From: Amanda Scholes on behalf of Planning.Responses
Sent: 10 December 2019 08:54
To: Planning Scanning
Subject: FW: WA/97/19/PL - Mill Ball - SDNP COMMENTS

RE: WA/97/19/PL - Mill Ball - SDNP COMMENTS

Further to your comments on this case, as attached, I have requested that the architect reduce the 2 storey glazed opening proposed to the northern elevation and include mitigation measures such as low transmission glazing or automated black out blinds used.

VIEW A - NORTH (MAIN ENTRANCE)

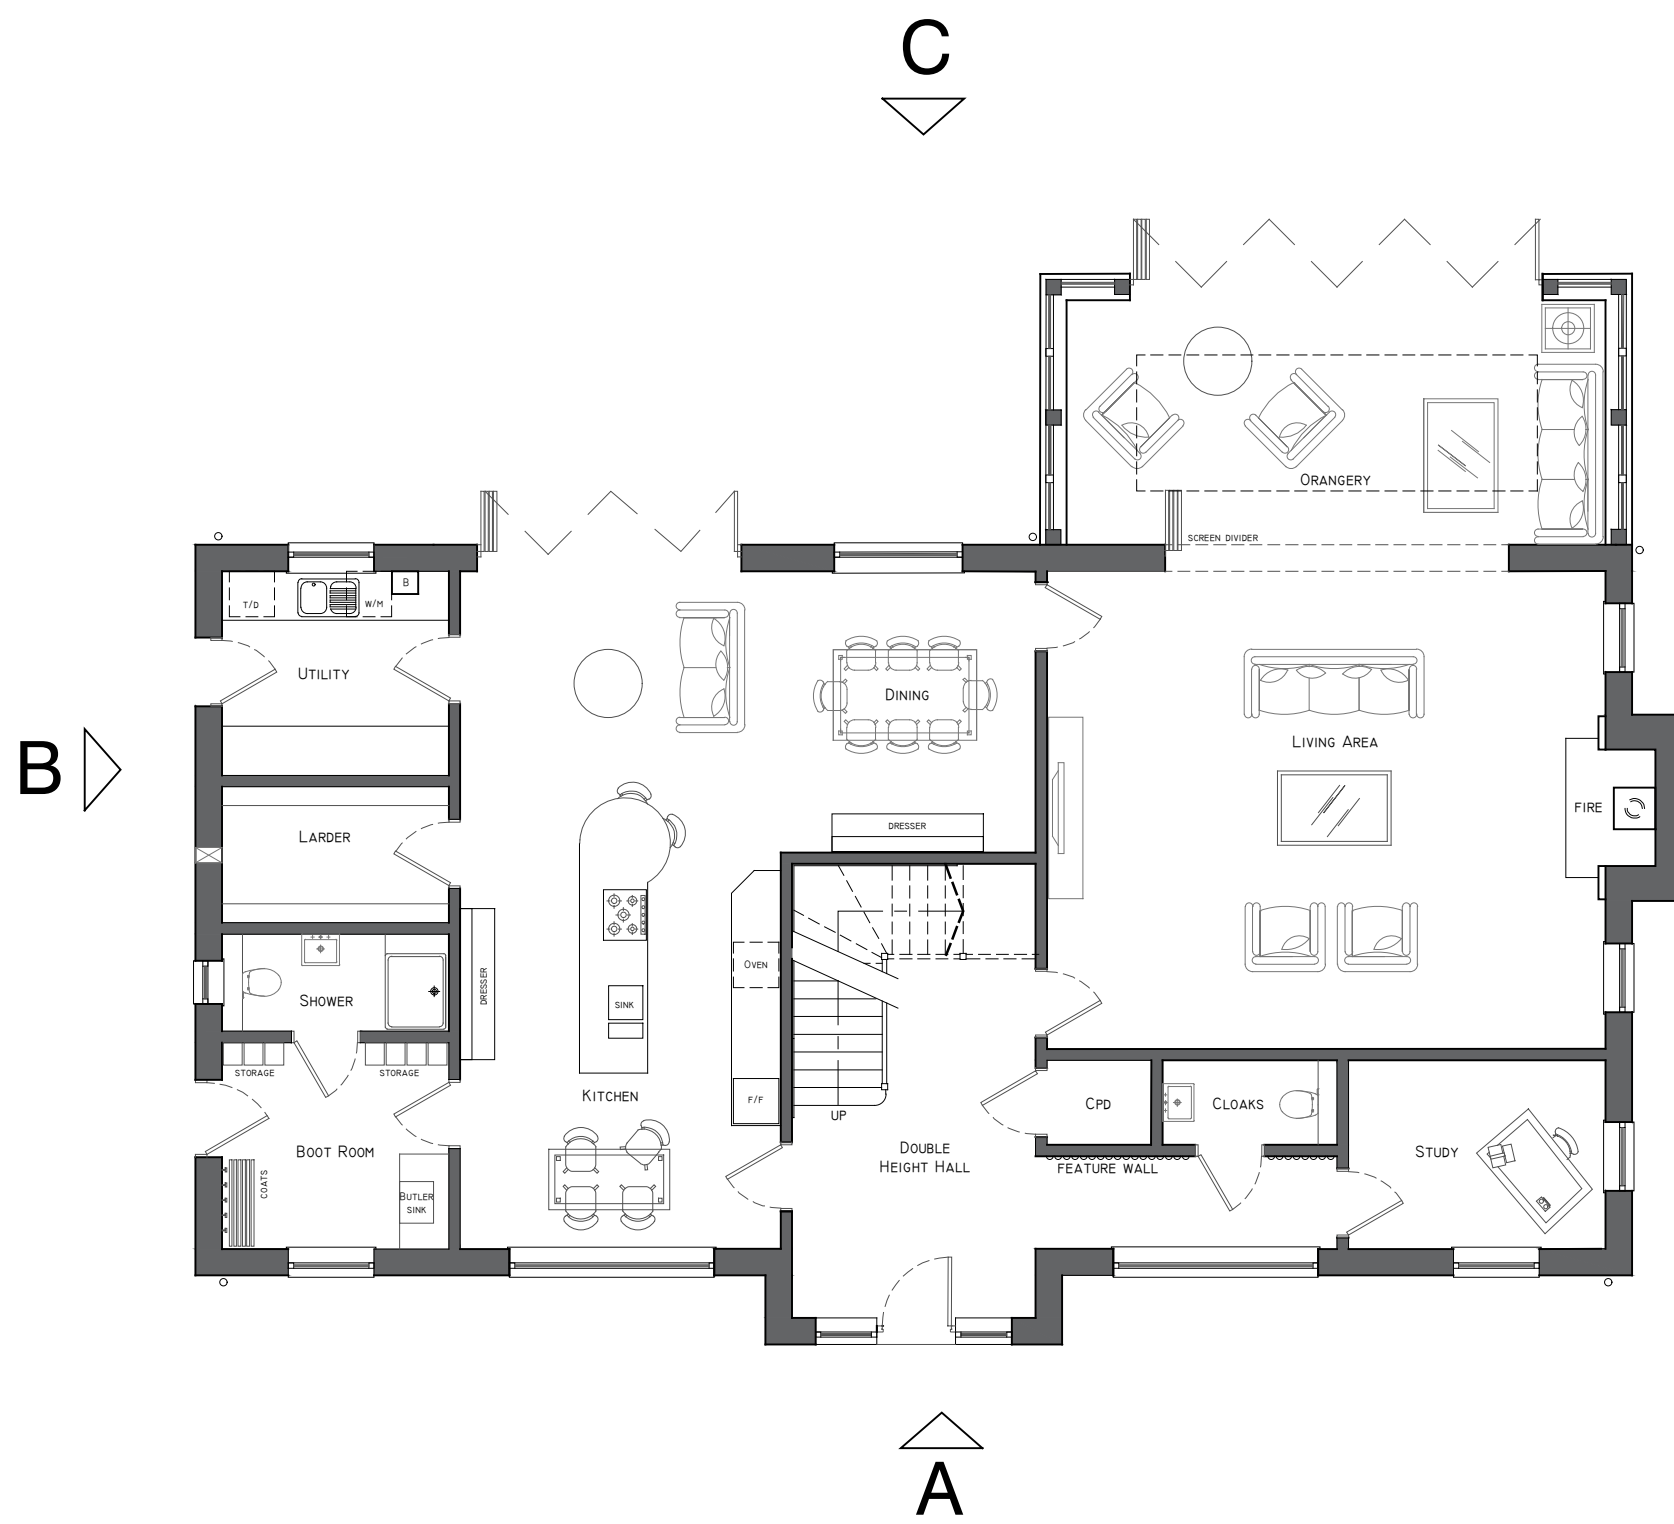
The client would preferably like to keep the windows sizes but is happy to include automated blinds to prevent light spill in the evenings. As the site is located outside of the SDNP and there is an existing light 'impact' caused by the existing house I would have thought this would be acceptable and even a minor improvement from the baseline? I have recently received consent for a new build dwelling within a dark area of the Park where blinds were considered acceptable for a number of new roof lights (that would potentially cause greater light spill upwards than the Mill Ball proposals). Could you advise if you consider the above inclusion of automated blinds to be acceptable please?

I think the use of automated black out blinds would be acceptable.

No development above damp proof course level shall commence until full details of the automated black out blinds, including the proposed blind material (which should be fully opaque), the operating system and the timings of use (dusk until dawn), have been submitted to and approved in writing by the local planning authority. The blinds are to be retained and used in accordance with the approved details for the lifetime of the development hereby approved.
